**RESPONSE TO REQUEST FOR ADDITIONAL INFORMATION
SSD 49295711 MOD 2 – HARBOURSIDE SHOPPING CENTRE REDEVELOPMENT – SSDA 2**

This letter has been prepared by Ethos Urban on behalf of Mirvac Retail Sub SPV Pty Ltd (Mircac) in response to items raised by the Department of Planning, Housing and Infrastructure (DPHI) in the Request for Additional Information (RFI) for SSD 49295711 MOD 2, dated 19 September 2024.

Figure 6: Promenade Indoor and Outdoor Dining and L1 Event Use – Night – R8 and R12

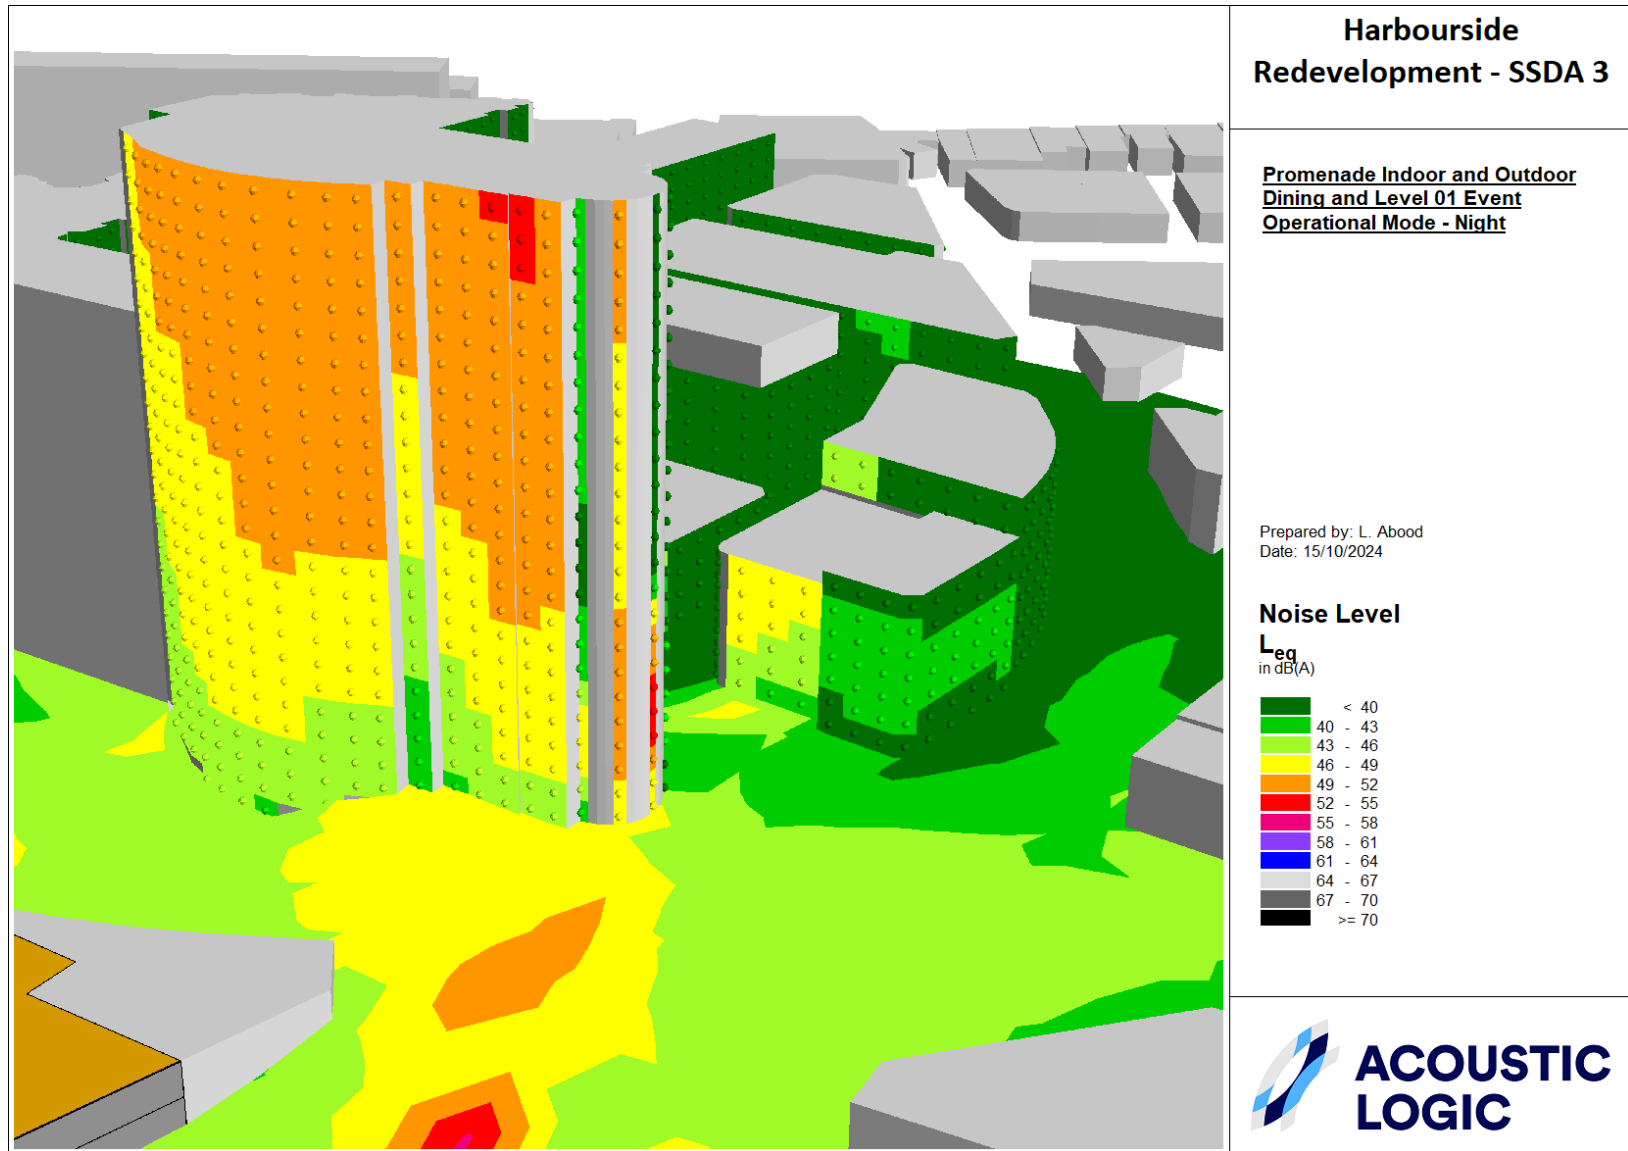
4. Acoustic impacts	
The applicant is proposing an event and conference centre on level one which is in addition to the previously allowable commercial space. The City is concerned that this area will generate a large volume of patron noise and noise from amplified music should events take place which will then impact the future residents in the tower and	Acoustic Logic have undertaken further assessment of the proposal, including factoring in the proposed operable façade along the eastern elevation (refer to Attachment A).

Item	Proponent's Response
surrounding residents in the area. An acoustic statement has been submitted which has stated that the event and conference space is primarily located internally and that there is an operable facade during quieter periods. The City recommends that more information be provided to fully assess the impact on the surrounding environment to ensure that appropriate acoustic treatment is undertaken at design stage. The applicant is to assess the event and conference area at full capacity/worst case scenario and demonstrate if further acoustic treatment is needed to ensure noise sensitive receivers are not affected by the operation of this area. This is to be assessed against the City's standard 'noise entertainment condition'.	Acoustic Logic confirm that the absolute worst-case usage of the Level 1 conference and event use complies with relevant NSWL&G standard noise conditions at the nearest noise sensitive receivers during daytime and evening periods (Between 7am and 10pm). Mitigation measures are required to be implemented between 10pm and 12am, where the eastern façade is required to be closed in instances where live music is laying, in order to achieve relevant acoustic requirements at surrounding receivers.
